16th July 2018

Application for Lawful Development Certificate for an Existing Use or Operation or Activity including those in breach of a planning condition.

Development Lawful development certificate for the use of an annexe as an existing single family dwellinghouse.
Location Evergreens Level Mare Lane Fontwell

South Elevation

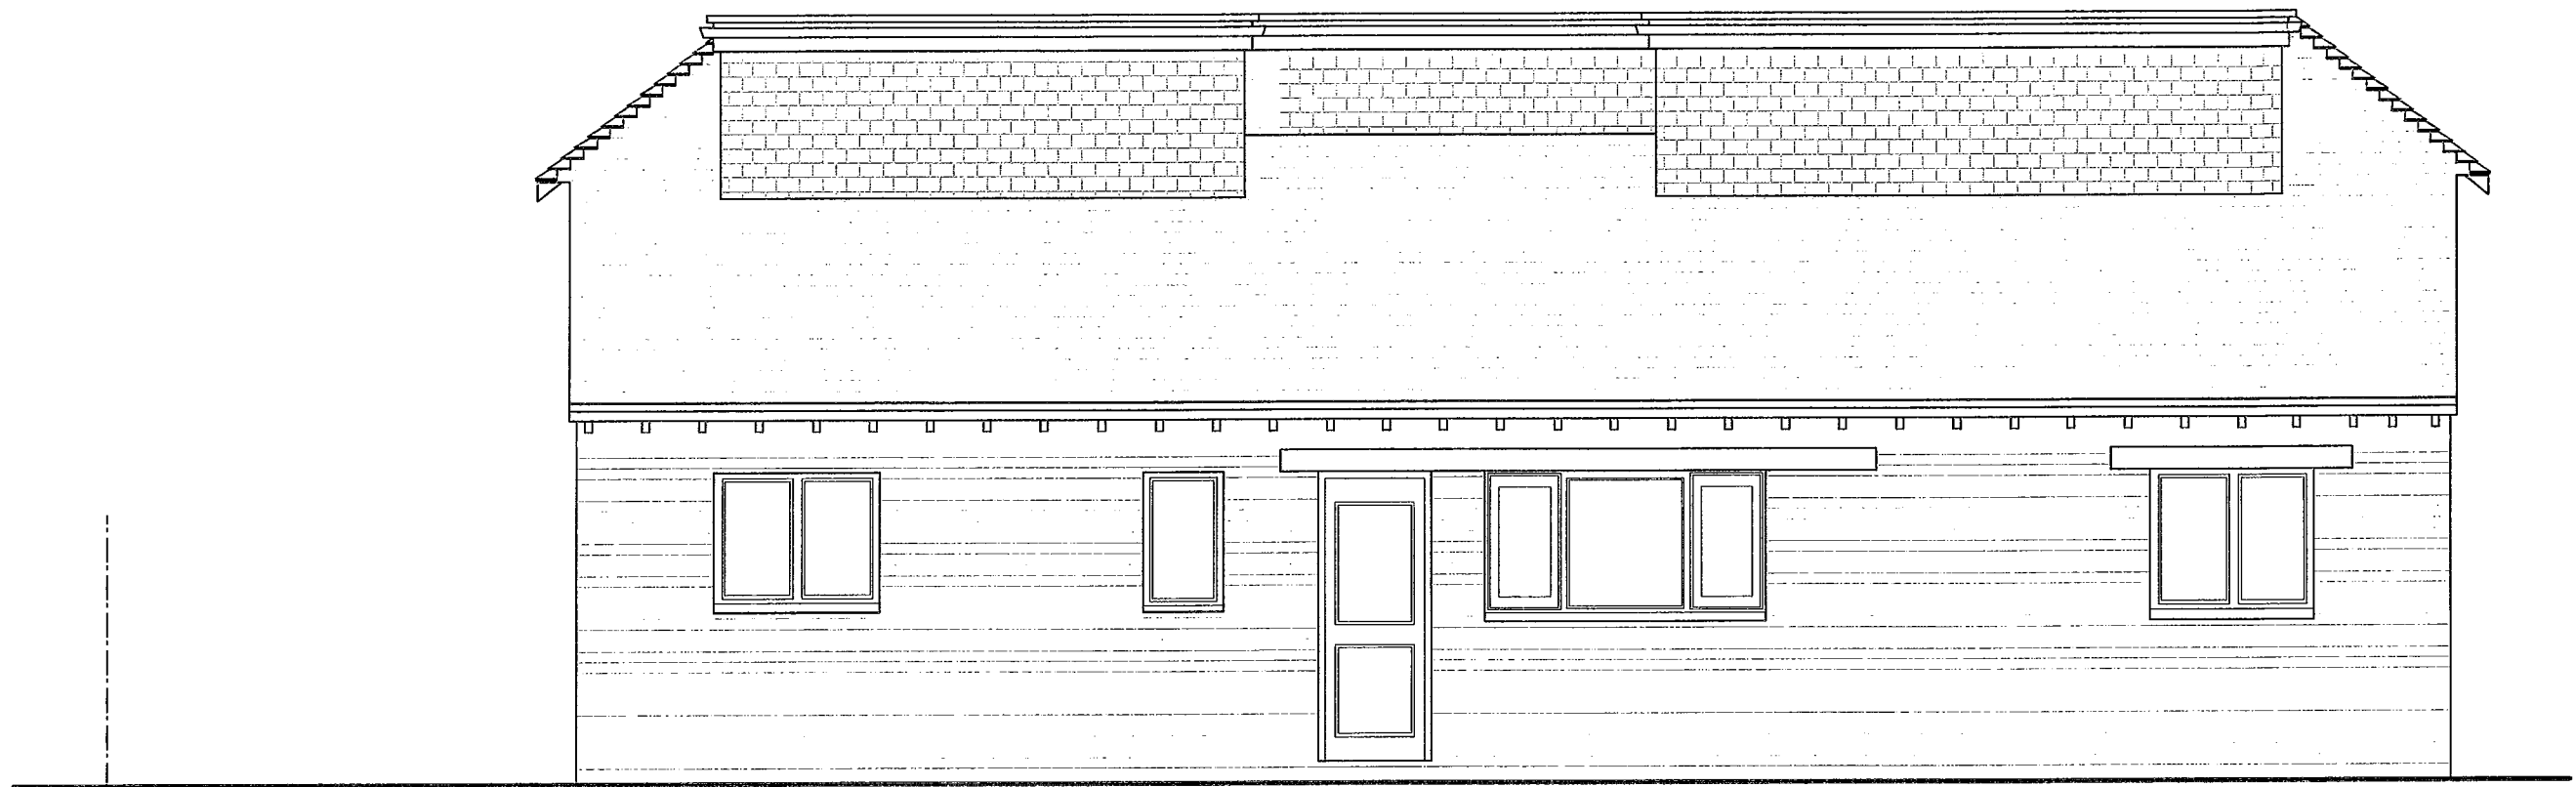
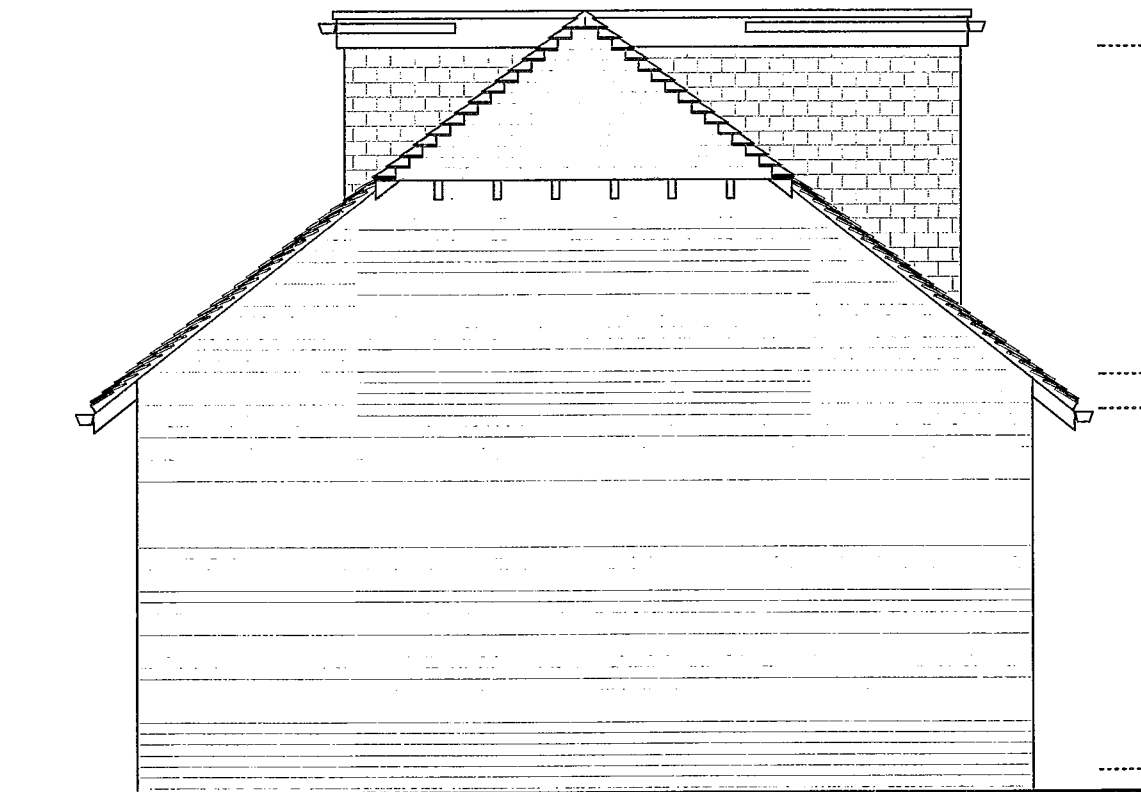
Two south elevations have been provided. Please provide a north elevation.
